Application for a non-material amendment following a grant of planning permission.

ERECTION OF 2 NO DETACHED GARAGES

2017 / 0379

**8. Non-Material Amendment(s) Sought**

GARAGE 2

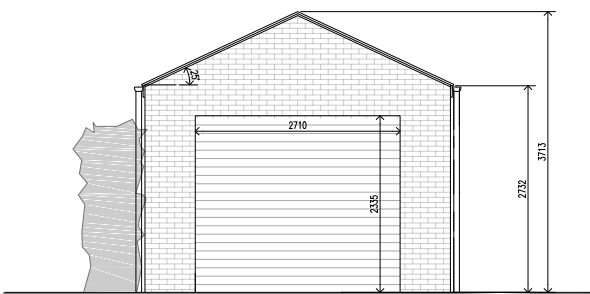
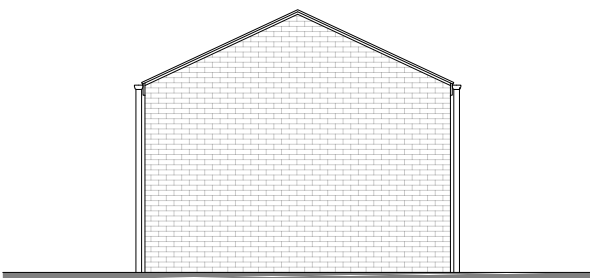
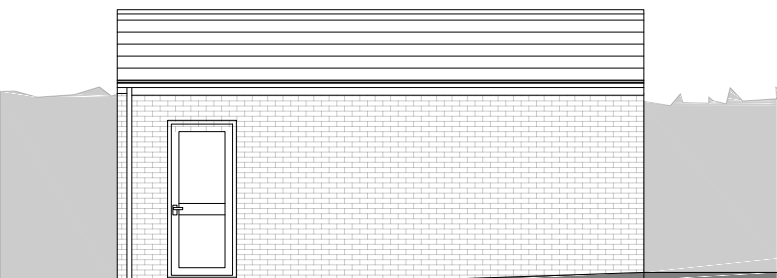
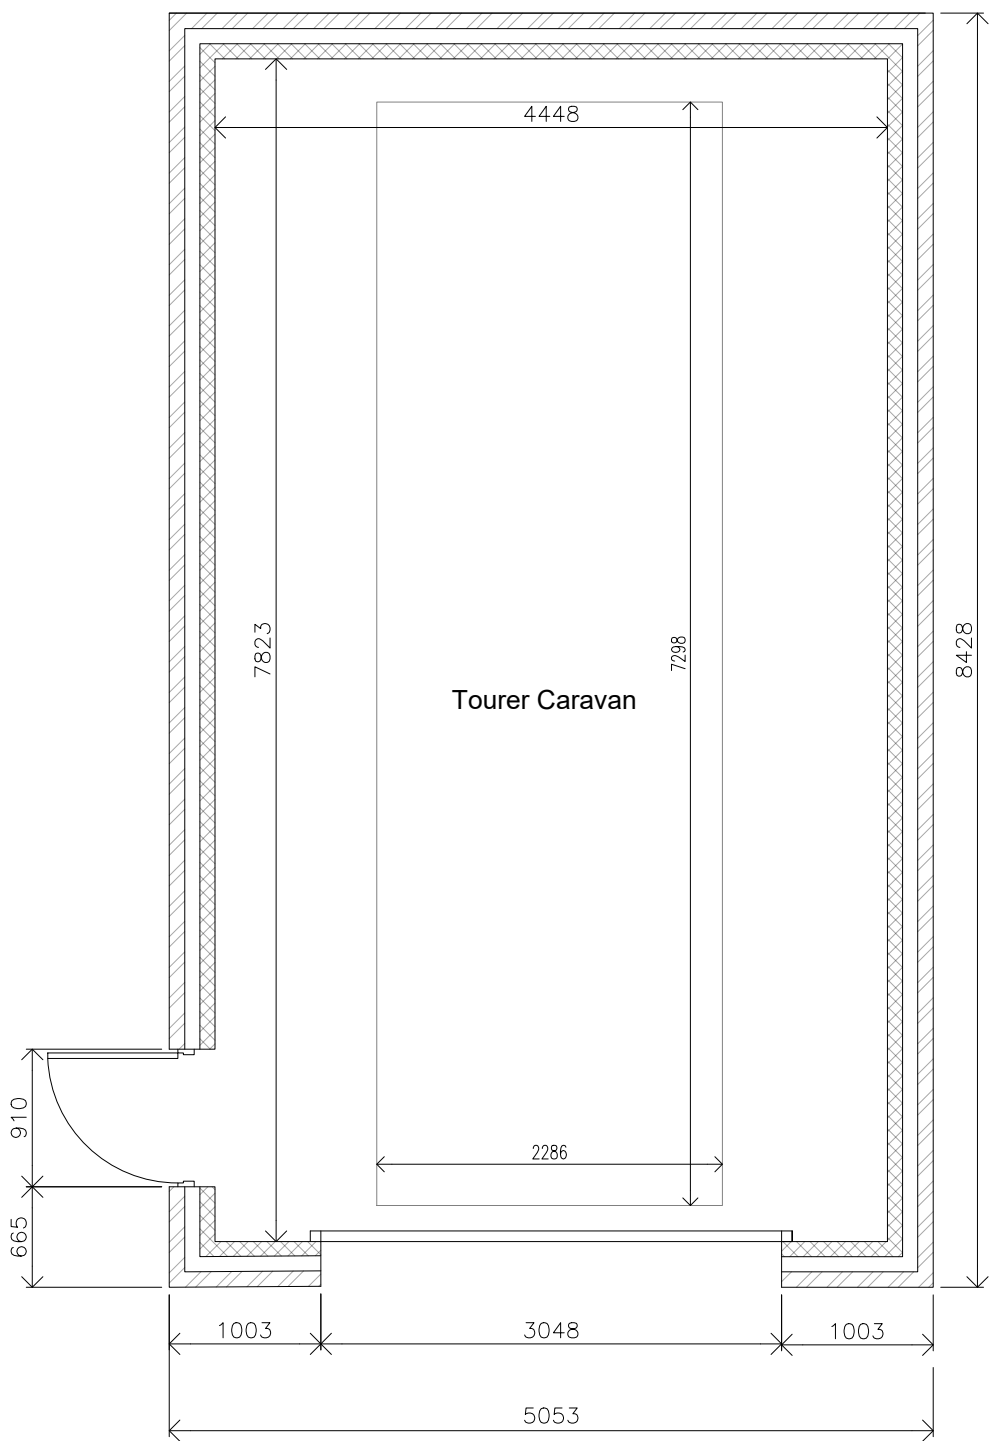
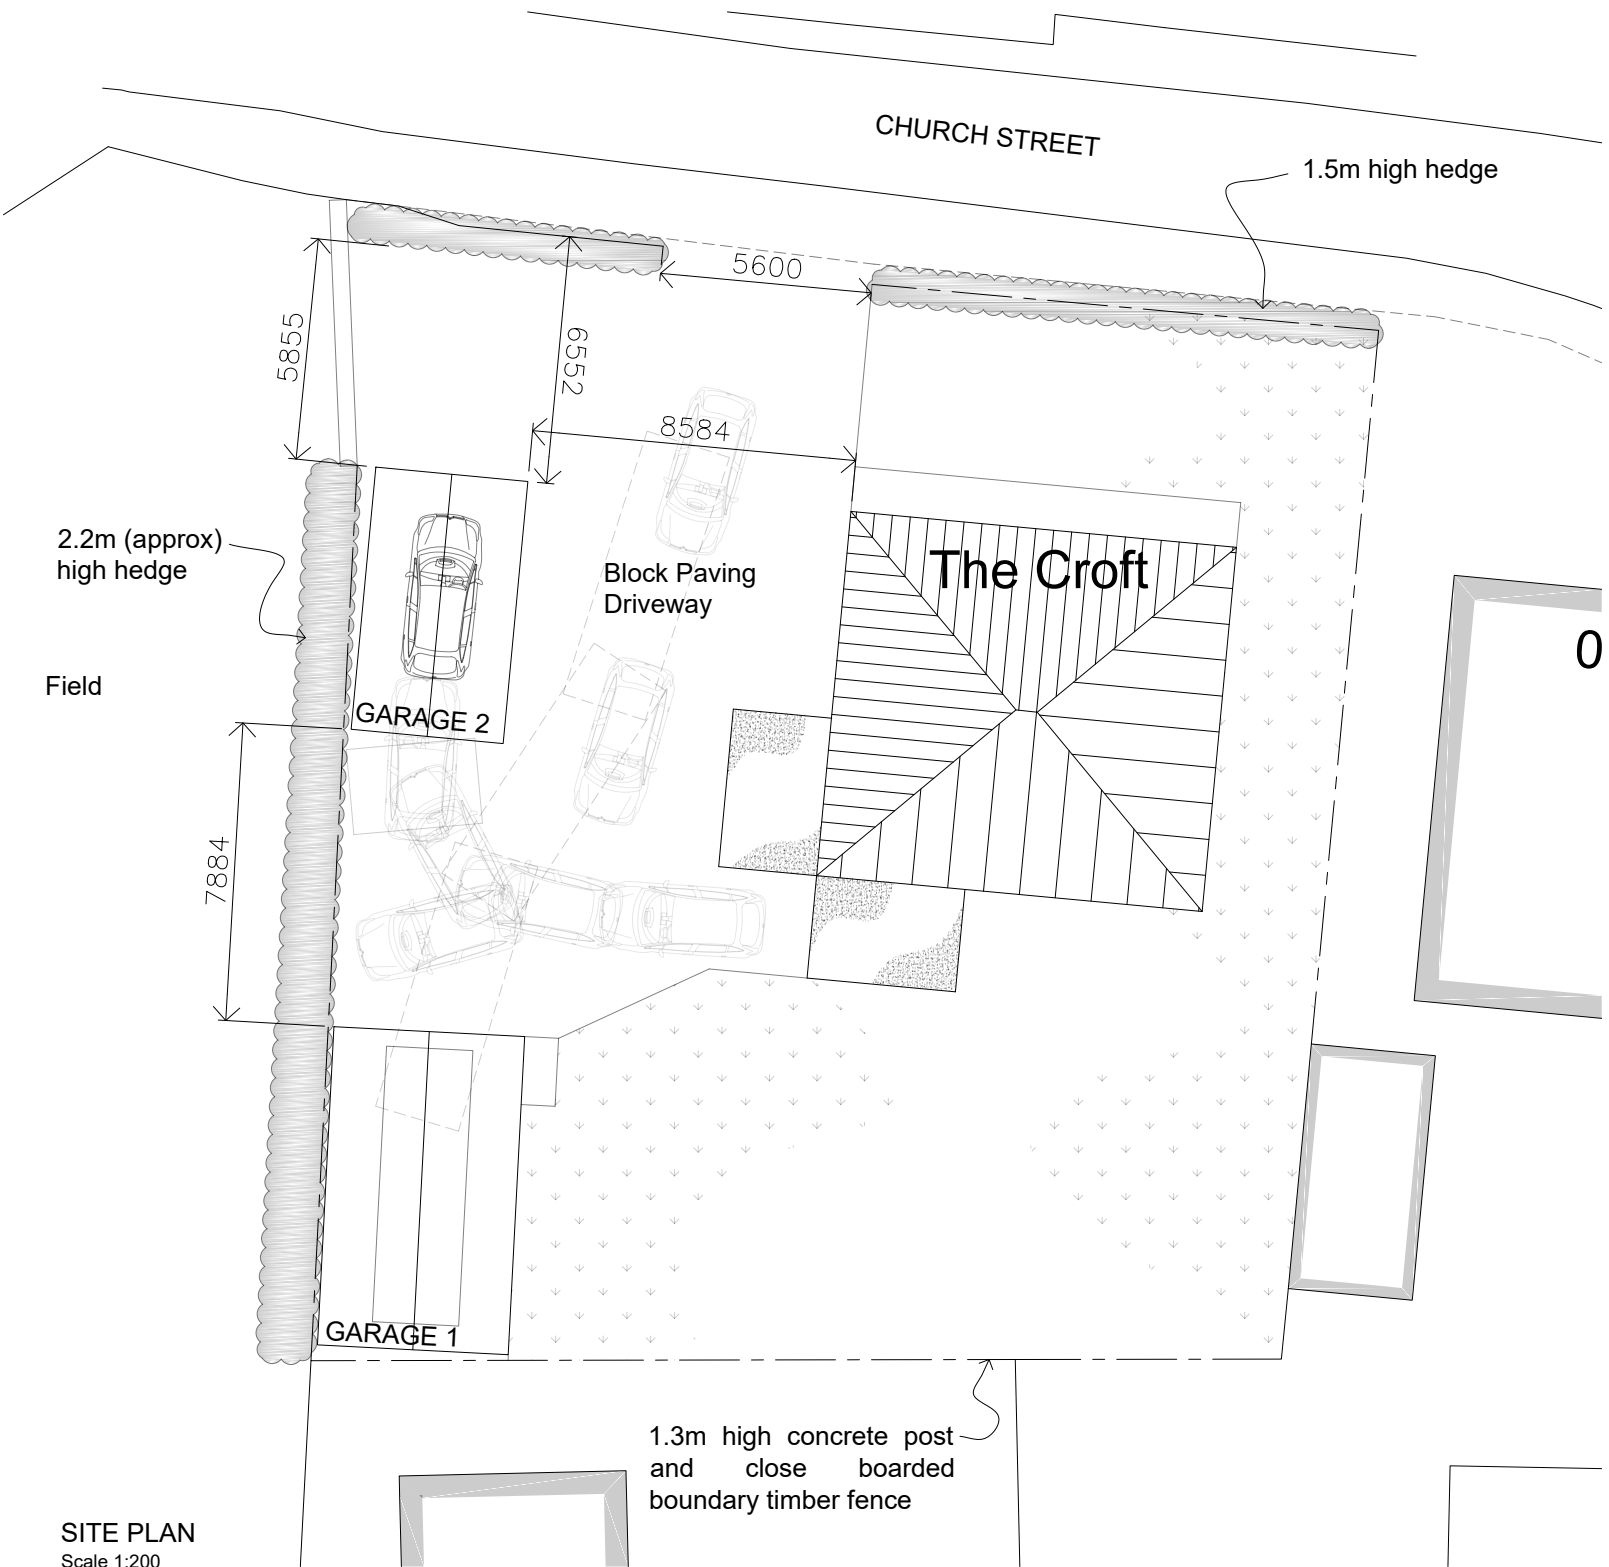
PROPOSED GARAGE NO 2 - MAIN GARAGE DOOR TO BE
HANDED SO GARAGE MAIN DOOR OPENS FACING GARAGE
NO 1'S DOOR

MAKES MORE SENSE FOR ACCESSING BOTH GARAGES

1707-101A-PLN-P-E-SLP
